14/10/2025

AP Ref: 131401

DPHI Ref: MP06_0228-Mod-30

RESPONSE TO REQUEST FOR INFORMATION SHOALHAVEN STARCHES EXPANSION PROJECT (MP06_0228-MOD-30)

Figure 4: Process Flow Diagram – CO₂ Plant Facility.

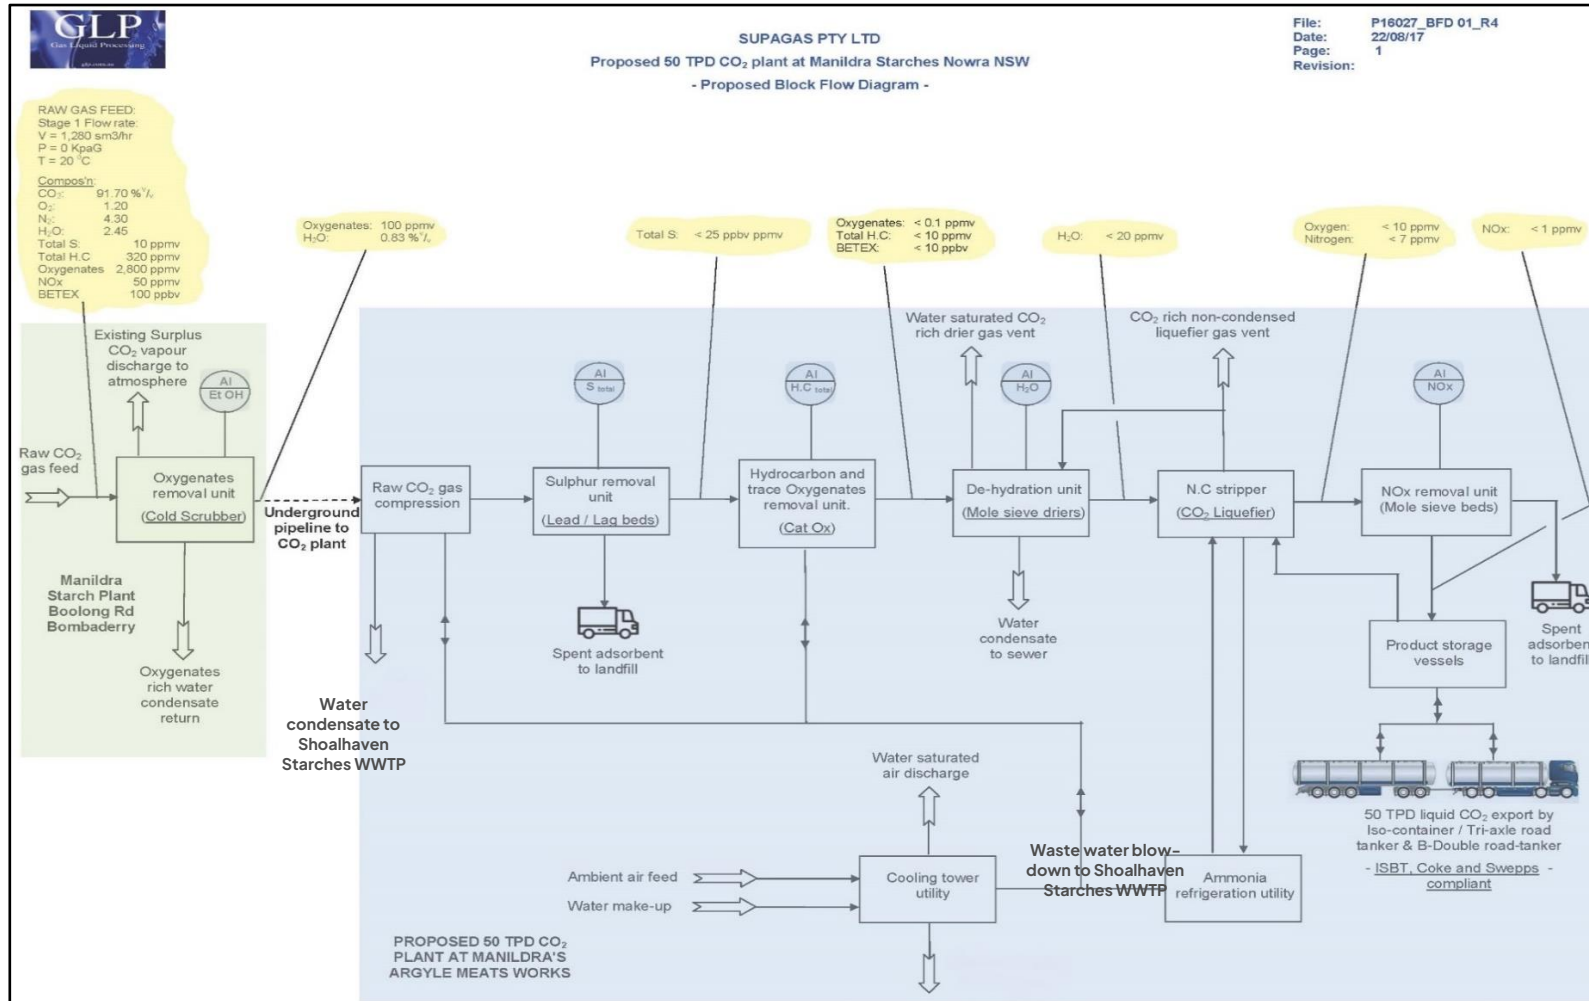
However, the process flow diagram of the CO₂ plant (p25 Modification Report) and information provided indicates potential of wastewater being generated from, a number of sources, including the cold scrubber, CO₂ compressor, CatOx unit, CO₂ liquefier and ammonia receiver.

Recommendation: *The Modification Report should confirm the expected volume of wastewater to be generated by the additional CO₂ plant and capacity of the existing WWTP to accommodate the additional volume. This should include details of the capacity of the existing WWTP and current and approved wastewater volumes from the development site.*

In a written submission prepared by the Manildra Group dated 3rd September 2025 and previously supplied to the Department, it was indicated that the expected increase in wastewater volume generated by the additional CO₂ plant is 27 KL per day which represents 0.2% increase in the current wastewater flows to the WWTP (about 11,000KL per day).

The existing Shoalhaven Starches WWTP capacity has a design flow rate of 9000 – 12,800 KL per day.

Manildra also advised that the organic loading rates (BOD & COD), the wastewater streams from the CO₂ plant have only trace amounts of organic compounds and therefore any organic loading rate increases to the existing WWTP is anticipated to be negligible.

Further, Manildra have subsequently advised that there are no additional wastewater loads associated with any recent approved, but yet to be constructed developments, at the site.
